Submission No.			71		
Organisation Name or Name of Submitter			Dublin City Council		
Item No.	Section Ref.	Page No.	Observation Statement	TII Response	
Written Submission from Dublin City Council's Chief Executive to An Bord Pleanála in relation to the National Transport Application for the Railway (MetroLink - Estuary to Charlemont via Dublin Airport) Order [2022]					
1	2.4.1 Planning Policy	22	While the Proposed Scheme is supported, it is important that the proposal adequately addresses conservation impacts along the route as well as the potential to improve green infrastructure and pedestrian and cycle connectivity and permeability.	<p>TII have included for the conservation mitigation of impacts throughout the Project and have appointed a Project Conservation Architect (PCA) to oversee the implementation of mitigation measures relative to the Built and Cultural (inclusive of Industrial) Heritage during the lifetime of the Project. The responsibilities of the PCA and proposed mitigation measures are outlined in the Construction Environmental Management Plan in EIAR Volume 5, Appendix 5.1 and MetroLink Cultural Heritage Strategy Rev.02.</p> <p>MetroLink will provide significant b

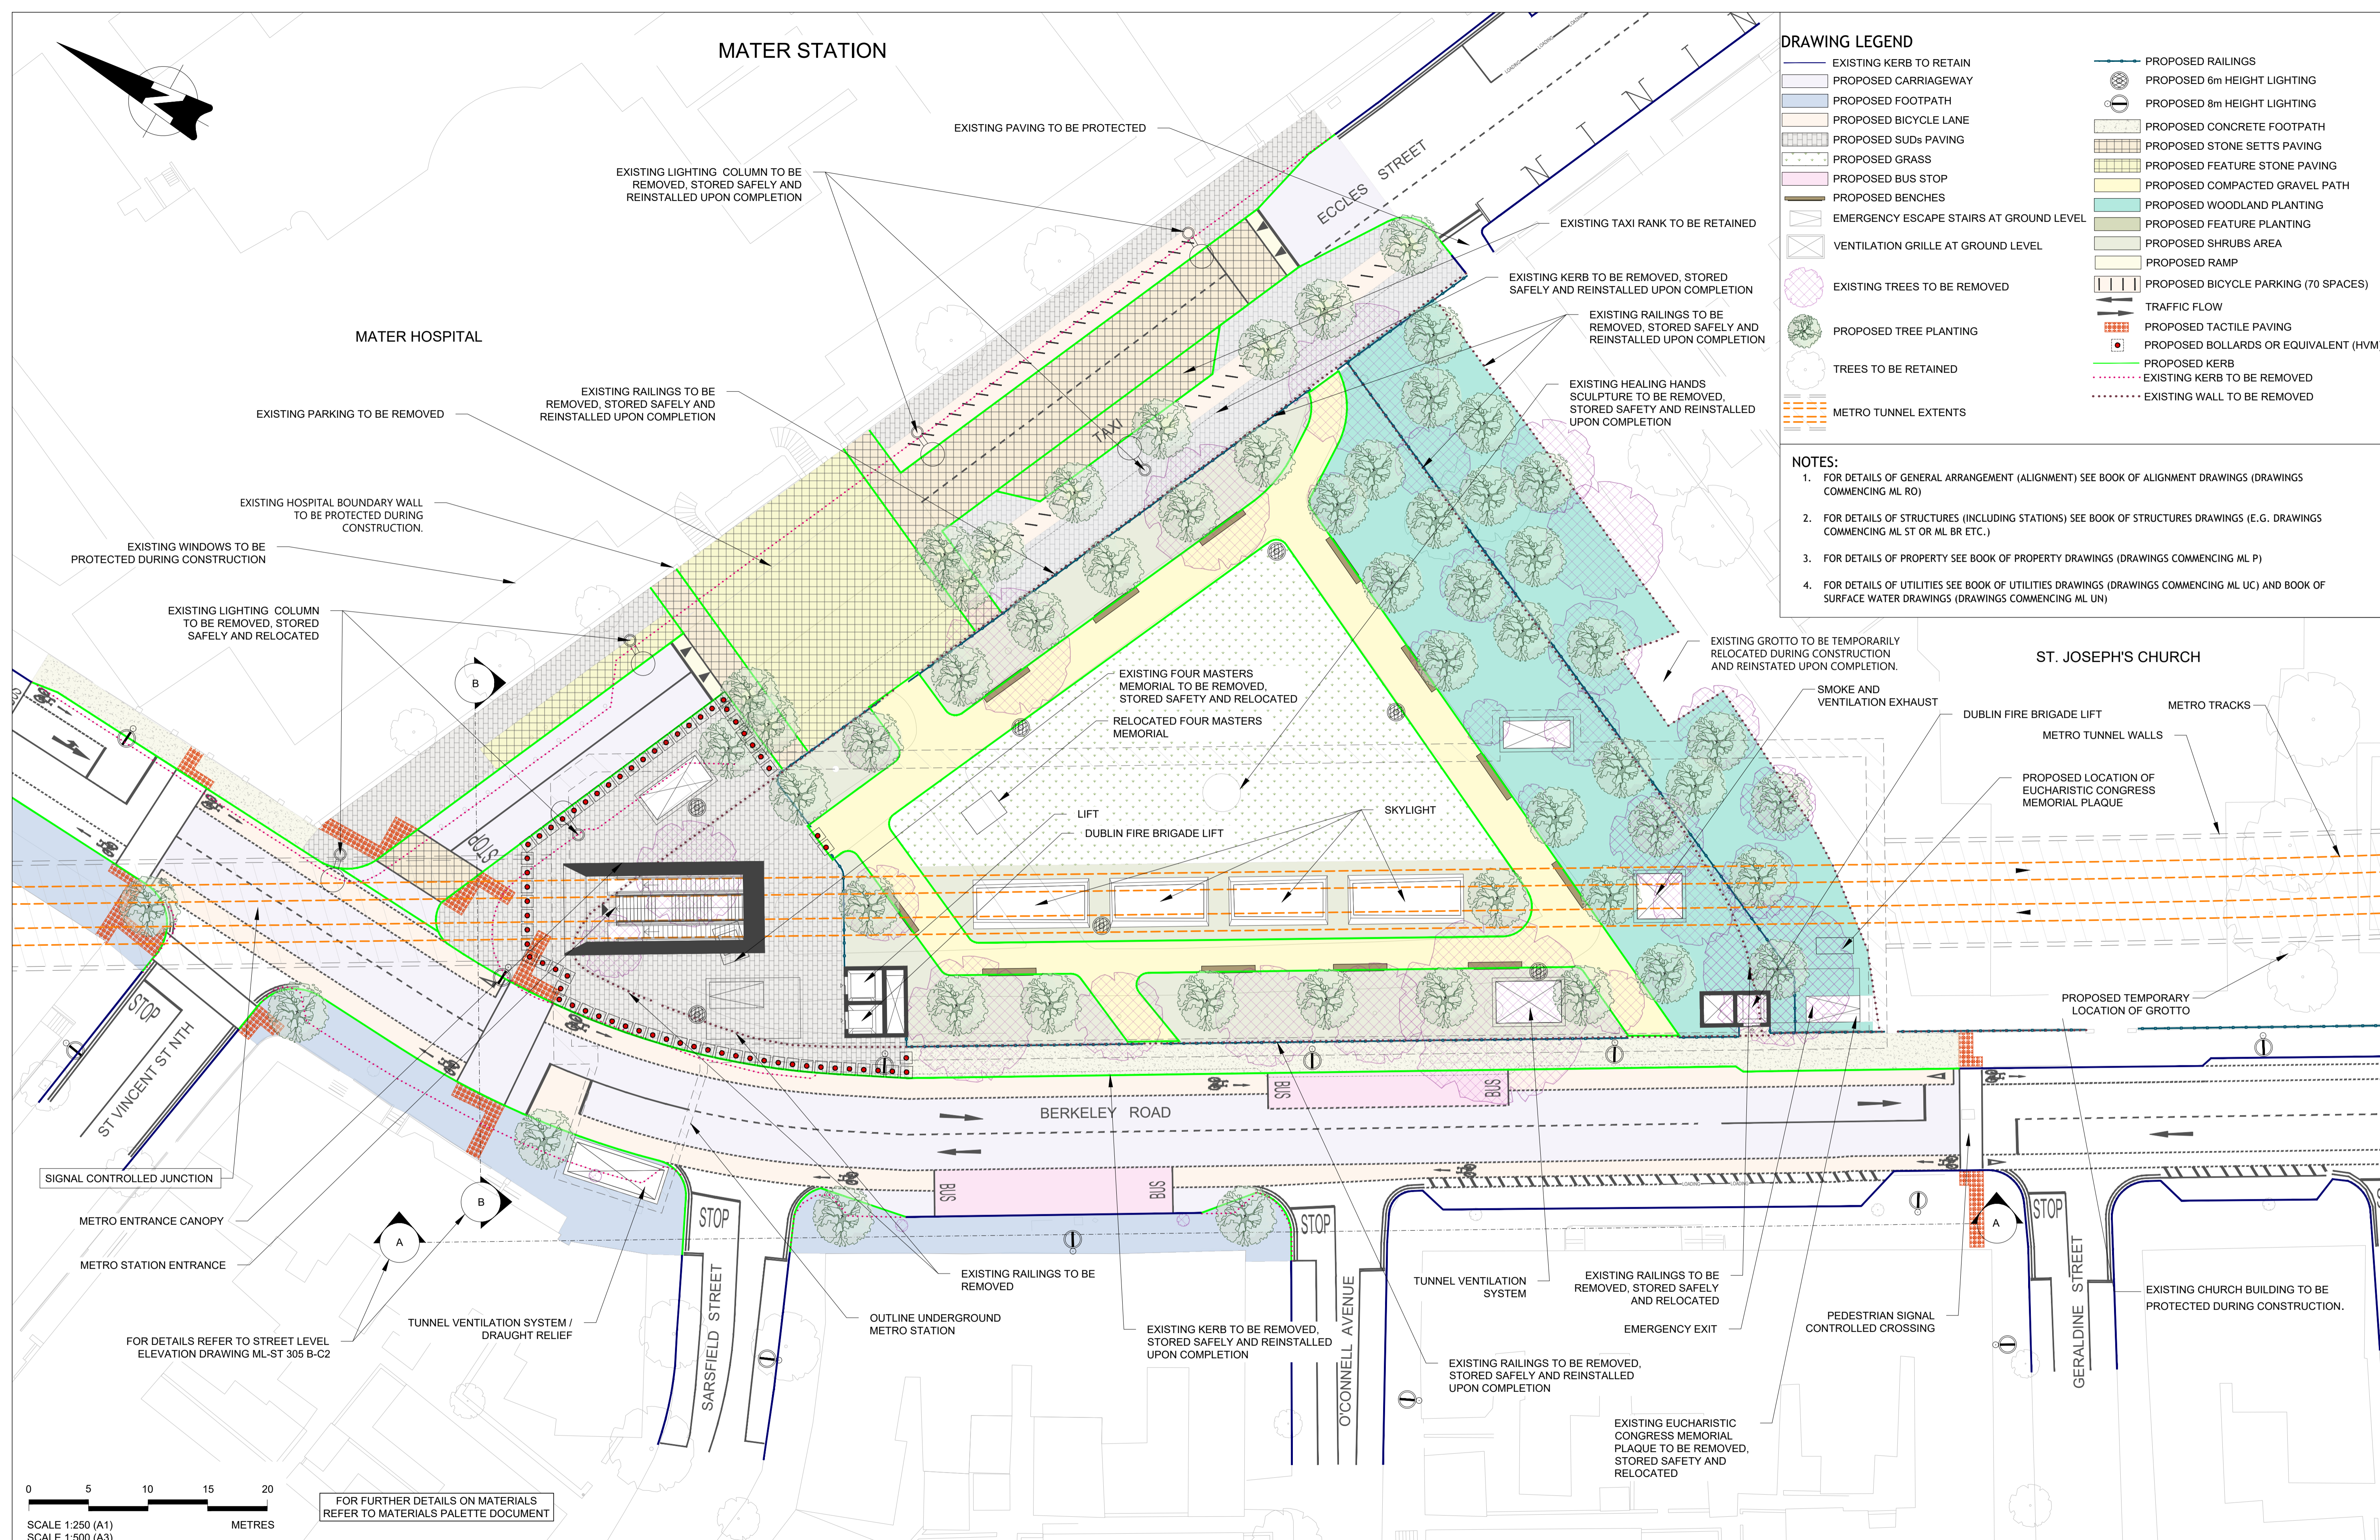
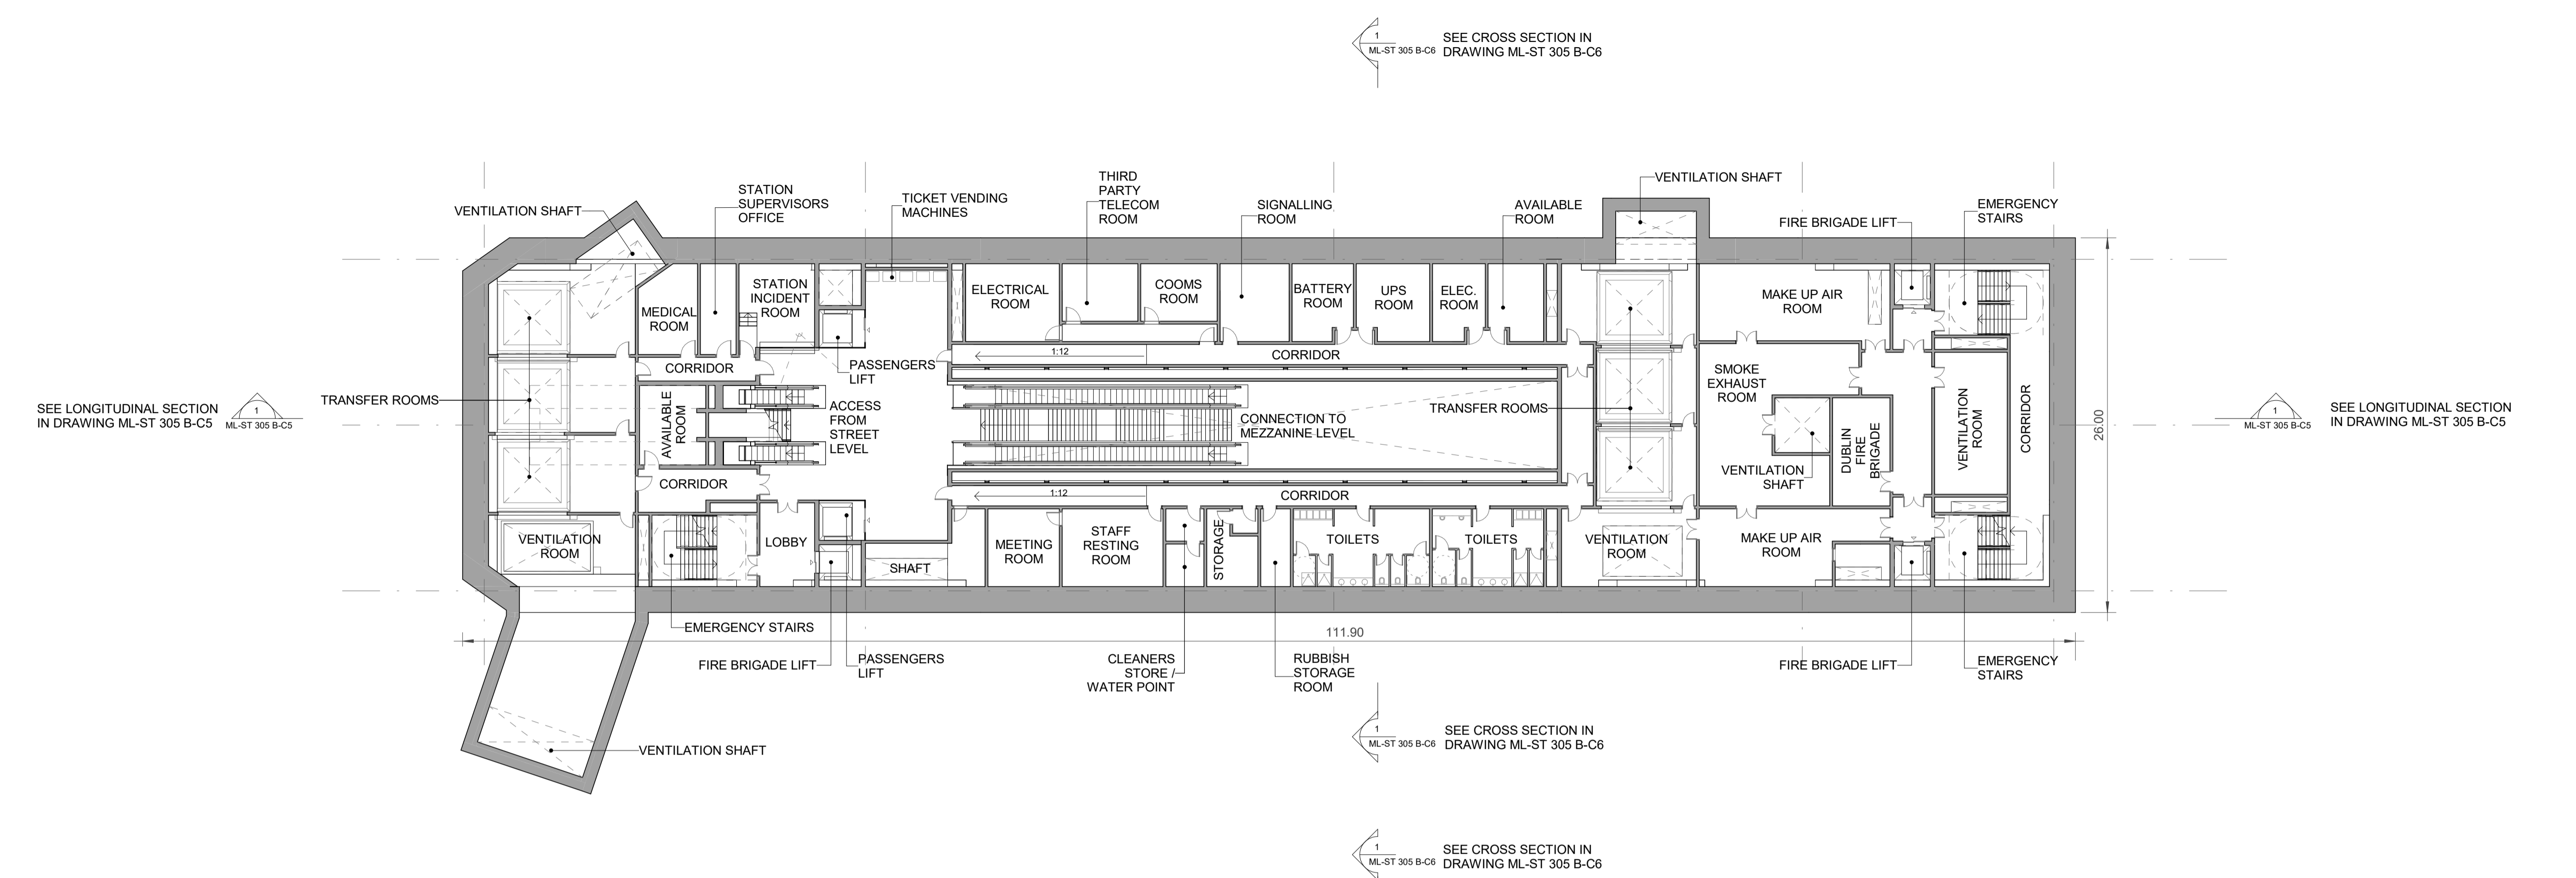
24	Conservation Section - summary of report - Mater	27	The visual impact of the new Metro Station and associated dark brick upstands/vents, lifts and other features on the Mater Hospital, St. Joseph’s Church and Four Masters Park is dominant and adverse and it is not clear how this impact could be improved without a radical relocation or screening of key items.	<p>TII disagree and believe the commissioning of internationally renowned architect Nicholas Grimshaw and Partners, has delivered a contemporary station design which is appropriate for a state of the art metro system such as Metrolink. Appropriately, significant emphasis is placed on the public spaces. Where feasible, the station concourse is a soaring space illuminated from above with natural light. Dublin's rich architectural heritage has been respected, but not copied in a pastiche imitation. In accordance with best conservation principles, as set out in the ICOMOS Venice Charter of 1964, the stations are architecturally distinguishable so as not to falsify the existing historic context. Reference and due respect to that context is made through the choice of high quality and appropriate materials and the scale of the interventions. At Mater station, the canopy entrance evokes the scale of park structures. TII believe the current station and surface level designs greatly enhance the public realm at all locations along the MetroLink route. There is a unifying commonality in the design of all stations, providing a consistent and coherent architectural language, which assists with orientation and wayfinding, and contributes a new architectural lexicon to the cultural iconography of the city.</p>

26	Conservation Section - summary of report - Mater	28	Further careful consideration and a conservation method statement is required of the proposed reinstatement of the historic railings, relocation of The Healing Hands, Four Masters Cross and Grotto and the overall realigned park layout.	<p>TII consider, as noted by responses (23), (24) and (25) above that they have already carefully considered the reinstatement of the historic railings, relocation of The Healing Hands, Four Masters Cross and the overall realigned park layout. The treatment of the grotto is addressed as a component of the curtilage so St Joseph's Church at response</p> <p>As outlined in EIAR Appendix A5.1, Construction Environmental Management Plan, (CEMP), where required, specialists with appropriate skills and experience will monitor on-site construction on behalf of TII. As previously noted above, in terms of reinstatement/relocation, this will include the MetroLink Project Conservation Architect with all heritage works being undertaken by a specialist heritage contractor.</p> <p>Prior to the commencement of construction, the Cultural Heritage Strategy will also be updated by TII’s Project Archaeologist and the Project Conservation Architect in relation to built heritage, who will remain involved during the duration of the project. The Cultural Heritage Strategy will remain live and will be revised as and when required following stakeholder consultation and further refinement of the design and construction procurement process</p> <p>TII commit to procuring the relevant works contractors supported by their own Conservation Architects to undertake any further necessary surveys and undertake the detailed structural assessments/method statements to protect sensitive sites in situ from the MetroLink works. If these assessments dictate that protection measures are required, TII will develop the form and nature of any measures required in accordance with Best Practice and all applicable guidelines and consult with key stakeholders in doing so. The assessments and mitigations will respect the sites historic setting and cultural significance. As noted above any required removals, conservation and reinstatement works will be done by a Specialist Heritage Contactor overseen by the MetroLink PCA.</p> <p>As detailed in Chapter 31 (Summaries of the Route Wide Mitigation and Monitoring), mitigations and mornioring measures set out in the Railway Order have been identified as environmental commitments and overarching requirements which shall avoid, reduce or offset potential impacts. Mitigation measures have been proposed for all impacts resulting in a moderate significance or above. Furthermore, mitigation measures have also been proposed for some impacts with a lower significance where such measures are routinely applied (for example in the management of construction-related impacts), or where, based on professional judgement, there would be a material benefit to the receptor.</p>
